Norfolk County Council

Deadline 2 Submission

The Drovers Solar Farm (EN0110013)

Deadline 2: 19th June 2026

Figure 2-1 Site Access Overview

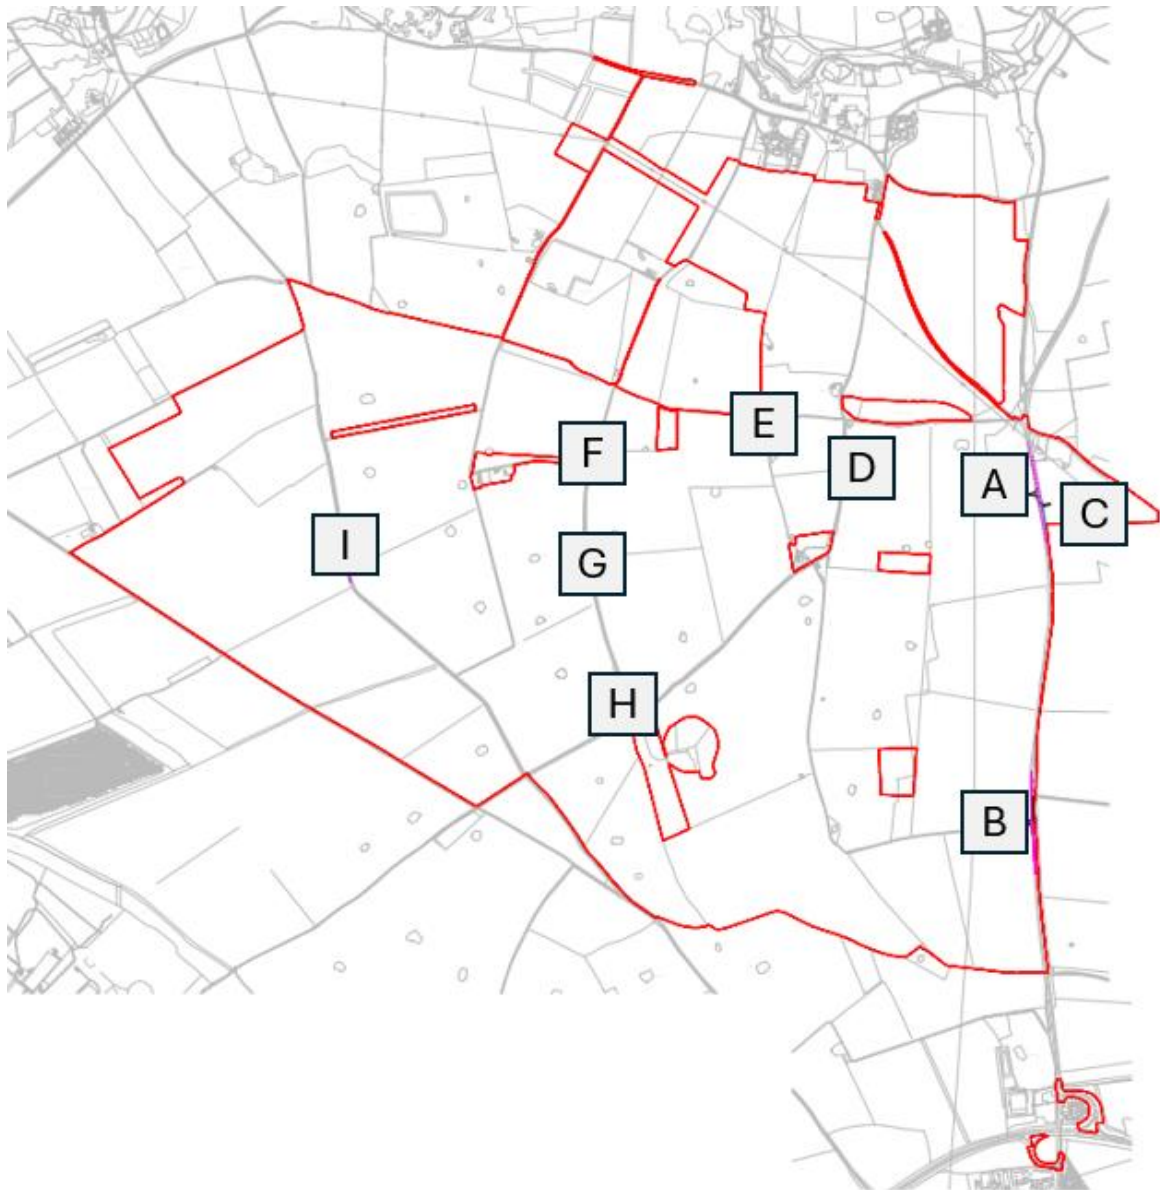
- 8.1. He County Council has, given the limited time available, the following detailed comments at this stage:
- 8.2. In relation to the outline Construction Traffic Management Plan [[REP1-052](#)], Figure 2.1 Access points I (River Road) and H (Fincham Drove) the County Council requests that clarification be provided as to whether these are a crossing to get to the Western extents of the scheme, or will they provide a primary access point as indicated in T2.1, like A/B/C.

Figure 4-1 Available Construction Routing Overview

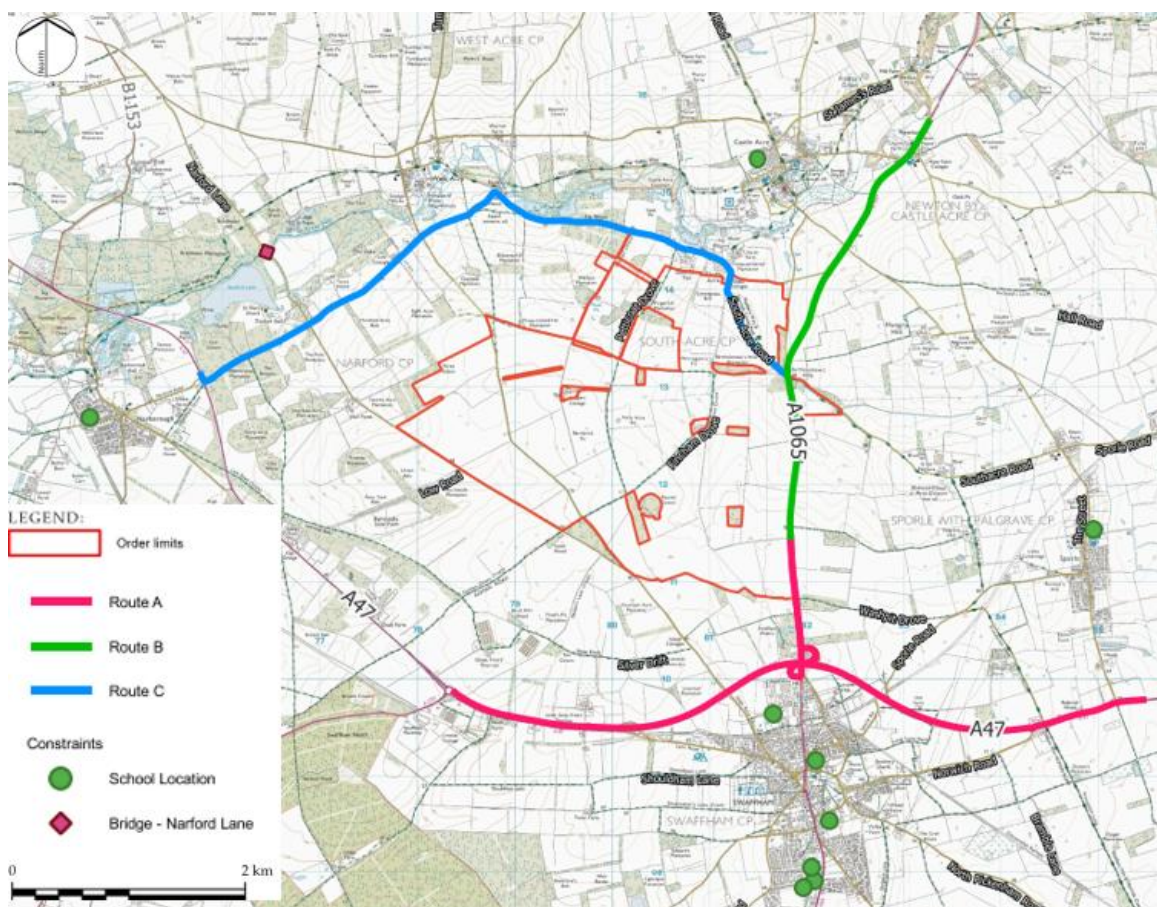
- 8.3. In relation to Figure 4.1, while the description states that Route C is not to be used by Heavy Goods Vehicles ("HGVs"), requests that clarification be provided about it is proposed that Light Good Vehicles ("LGVs") will use this route? If so, could anticipated traffic numbers be provided to allow assessment. If all construction traffic is intended to use the main access points on the A1065, it would it is recommended that Route C be removed from the proposals.

Figure 2-1 Site Access Overview

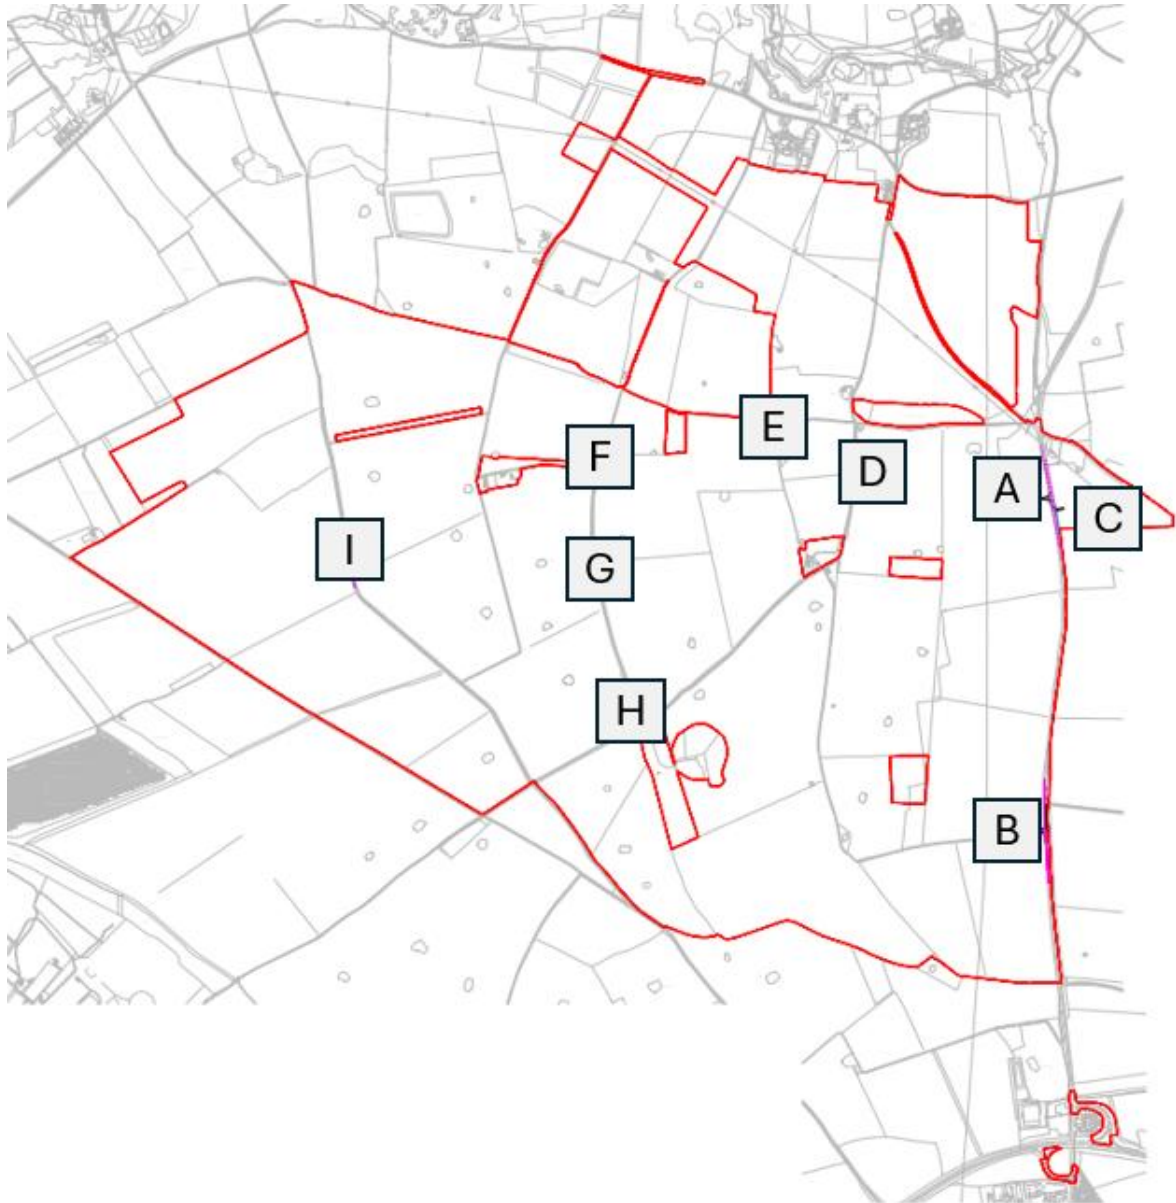
- 8.6. In relation to outline Operational Traffic Management Plan (Clean) [[REP1-056](#)], Figure 2.1 Figure 2.1 Access points I (River Road) and H (Fincham Drove) the County Council requests

that clarification be provided as to whether these are a crossing to get to the Western extents of the scheme, or will they provide a primary access point as indicated in T2.1, like A/B/C (i.e. the same comment as is set out above in relation to the outline Construction Traffic Management Plan [\[REP1-052\]](#), Figure 2.1).

Figure 4-1 Available Routes for Construction Vehicles

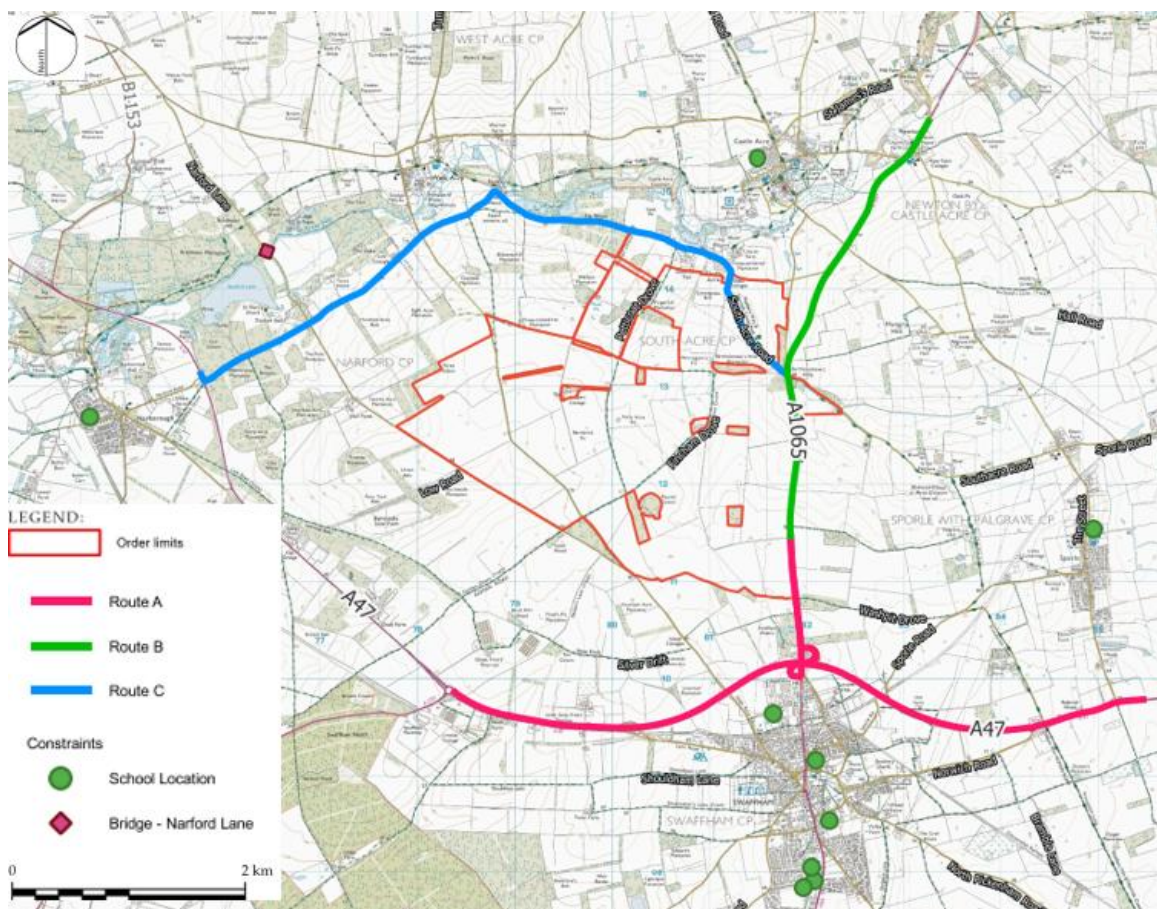
- 8.7. In relation to Figure 4.1, while the description states that Route C is not to be used by HGVs, requests that clarification be provided about it is proposed that LGVs will use this route? If so, could anticipated traffic numbers be provided to allow assessment. If all construction traffic is intended to use the main access points on the A1065, it would it is recommended that Route C be removed from the proposals i.e. the same comment as is set out above in relation to the outline Construction Traffic Management Plan [\[REP1-052\]](#), Figure 4.1).
